This is to certify that DELTA REALTY LLC – JABBAR'S  
AUTO SALES

Located At 710 FOREST AVE

Job ID: 2012-03-3559-CH OF USE/AMEND 2012-45749

Re: Essa Repair Garage, 710 Forest Avenue, Portland, ME

1 CODE PLAN
 1/4" = 1'-0"

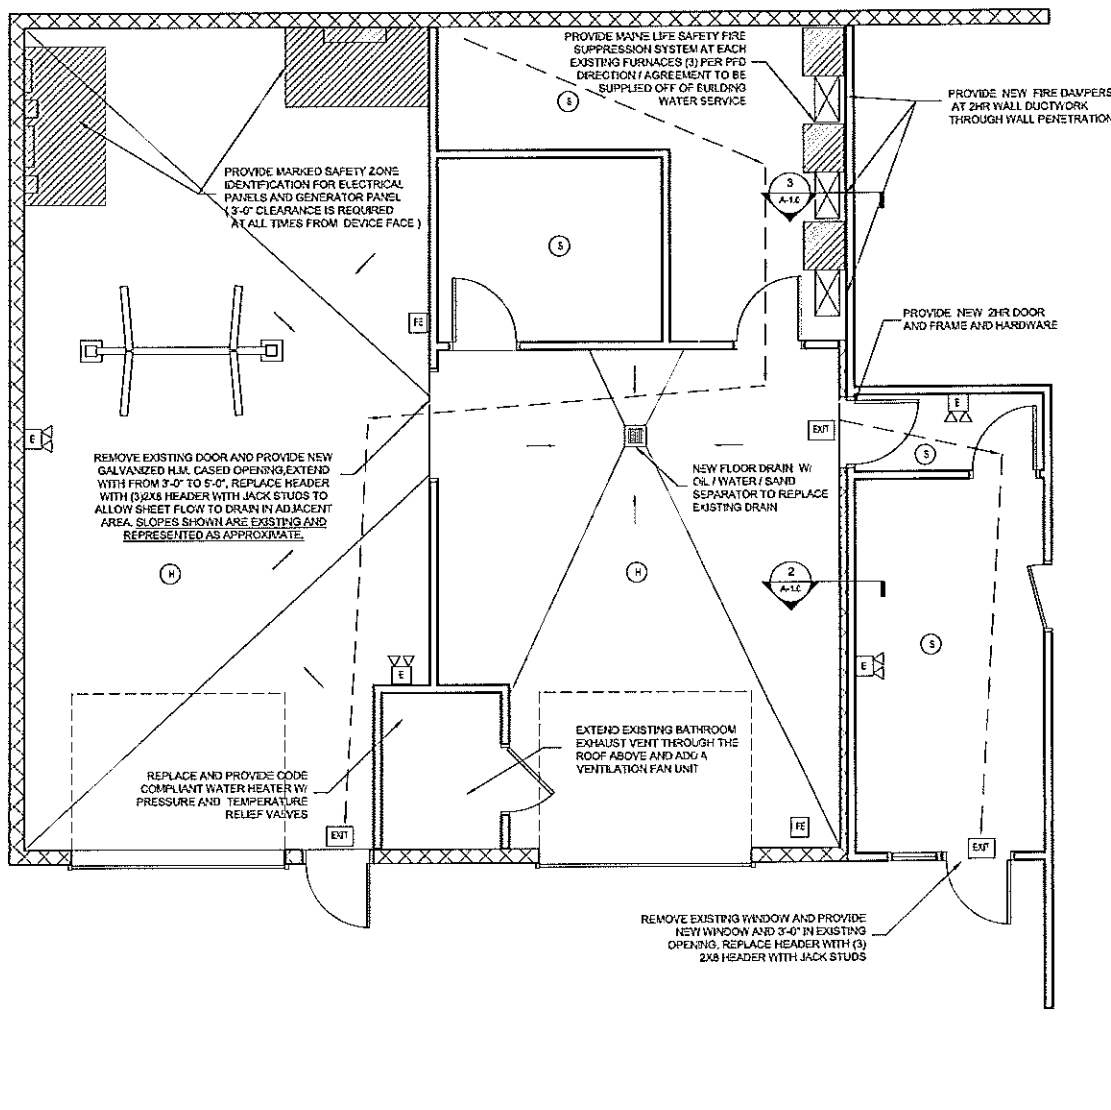
- 1.) Incorporation of a Fire Separation Wall is required, it is proposed to construct a 2hr gypsum wall board and wood stud separation wall at the existing vehicle repair bay and office demising wall location (this will incorporate use of the existing wood studs and add new gypsum wallboard to supplement existing gypsum wallboard per UL Designation UL263 – Design U301, attached) and provide a 1-1/2hr door (reverse existing swing) with closure device and lever hardware. The existing concrete block finish shall be removed and not considered as part of the UL designated wall assembly.

- 4.) The existing electrical panels are wall mounted within the rear portion of one the vehicle repair bays, it is proposed that the floor be clearly marked by permanent means with a designation of clear floor area to be as wide as the panels and a minimum of 3'-0" deep for safety and access.

- 5.) Each area of the facility shall be marked for egress with emergency lighting, provide smoke detection (heat detection in the vehicle repair bay) and fire extinguishers (ABC rated)

- 6.) In order to use the office area opposite the proposed fire separation wall for a waiting room, it is essential that a new exterior door be added for direct customer entrance and exit from the exterior without access through a service bay, which is presently the case. The door and accessible route will be added next to the existing radio tower.
